Goulburn Mulwaree Council
Locked Bag 22
Goulburn NSW 2580

11 December 2025

Subject: Gunlake Modification 3- Western Emplacement (SSD-12469087-Mod-3)

Council has reviewed the Modification Report prepared by EMM, dated November 2025 and are generally supportive of the proposal. However, there are issues with the description of the vegetation present in the impact area, its biodiversity values and the locations of Biodiversity Assessment Method (BAM) plots used to collect data.

APPENDIX 8: WESTERN EMPLACEMENT EXTENSION AREA

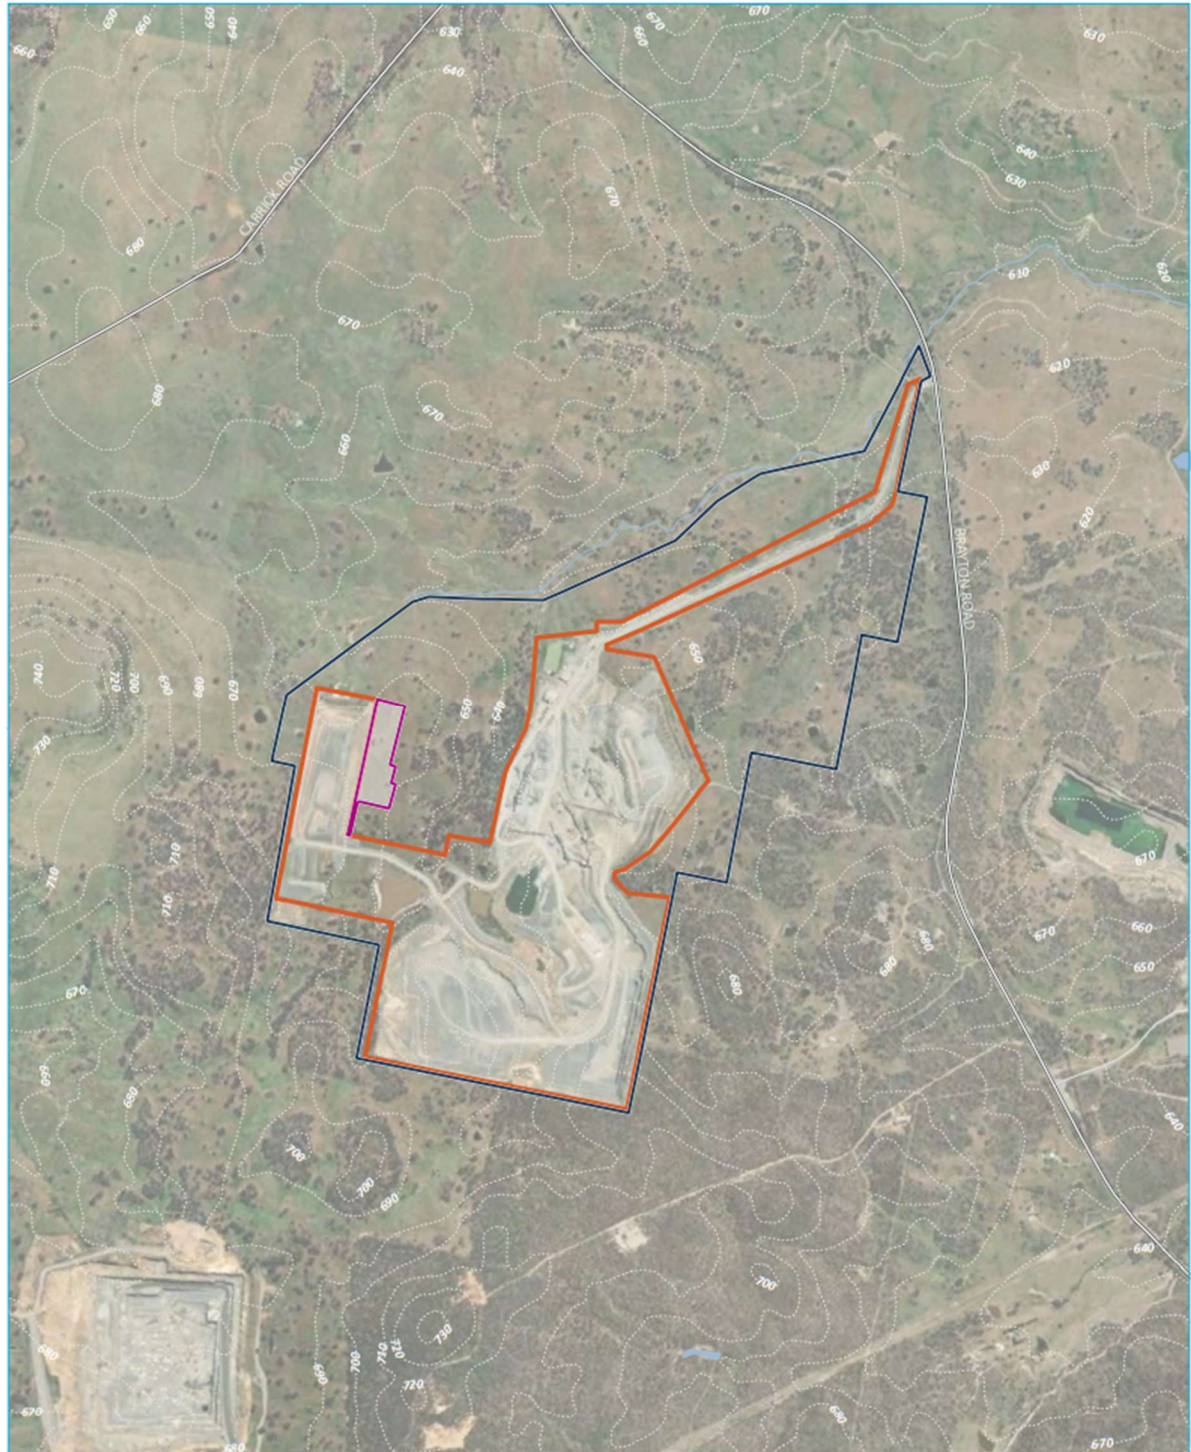
- The area is described as a derived grassland with scattered trees and shrubs, but the BAM plots appear to have been located to avoid trees. Aerial imagery and site photographs appear to show patches of significant regenerating Eucalypts, but BAM plots appear to have been located to avoid these areas.

- Examination of aerial imagery shows many large fallen trees and logs in the impact area, all of which also contribute to the Vegetation Integrity Score and ultimately to BOS Ecosystem Credits. BAM plots appear to have been located to avoid any areas featuring fallen trees and logs.

Overall, the VIS (Vegetation Integrity Score) provided by the BDAR is extremely low, and it seems this is because the BAM plots have been placed in areas that do not contain any logs and trees and is likely to be a significant underestimate of the true VIS score for the impact area.
